FW: Application EP/10/26/NMA - 7 Tamarisk Way

Subject: Application EP/10/26/NMA - 7 Tamarisk Way

Proposed Ground Floor Plan

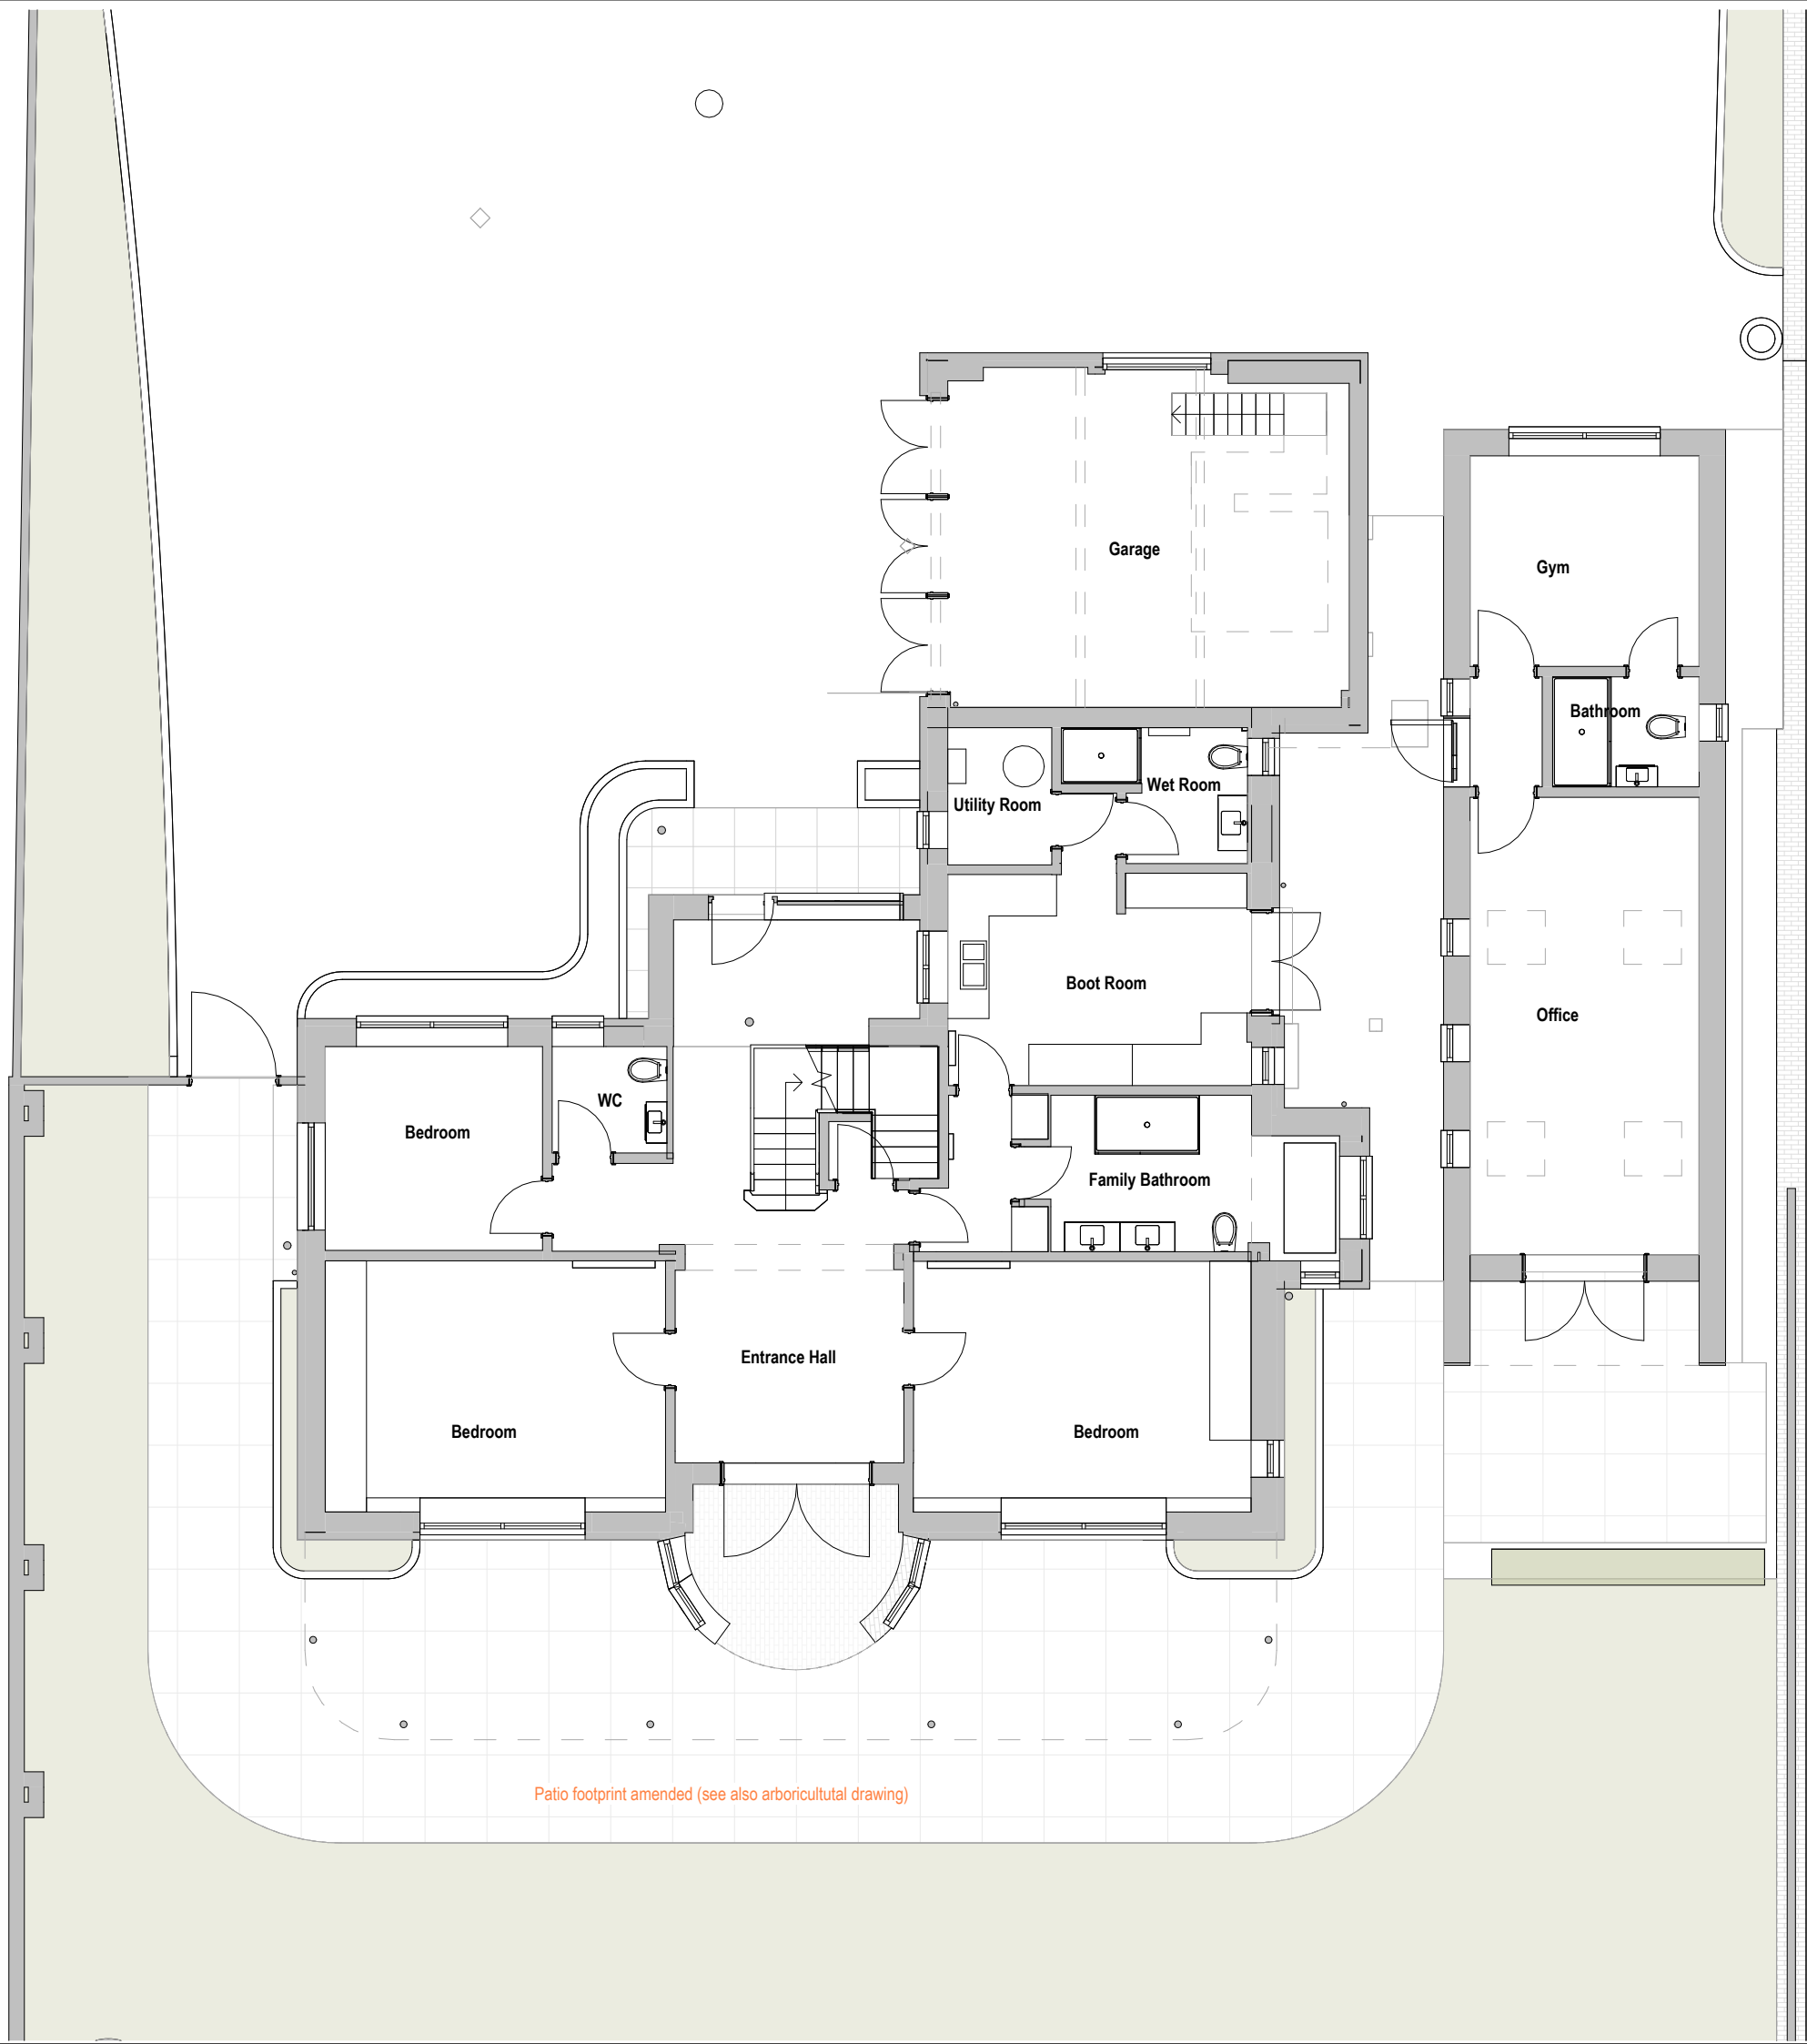
I hope you're well. I am just looking at your application for a non-material amendment to the proposals at the address above. I believe that the proposed alterations to the building are likely to be acceptable under an NMA application. However, I do have some concerns about the proposed extension of the rear patio, as this would extend further towards the protected tree to the rear. There is an annotation on the amended plans which advises me to see an aboricultural plan which I'm not sure I have received? In any event, I think we would need to consult the tree officer on the proposed amendments, and the proposals would conflict with the measures in the Arboricultural Impact Assessment and Method Statement. Therefore, I don't think this aspect of the application would be acceptable as an NMA. If you wished to proceed with the other amendments, the alteration to the patio could be removed from the application. If you wish to submit amended plans, I would need to receive these by 20/02/2025.

Sorry for the slight delay in coming back to you on this. Please see attached AIA and TPP from the arboriculturalist- the black line indicates the increase.

We do respect the procedures in place but are hoping that as the minor extension to the patio is exceptionally minimal (less than 2% additional impact) and not planned to be invasive or disruptive to the roots of the tree in any way (no dig specification), that this can still be considered within the NMA please.
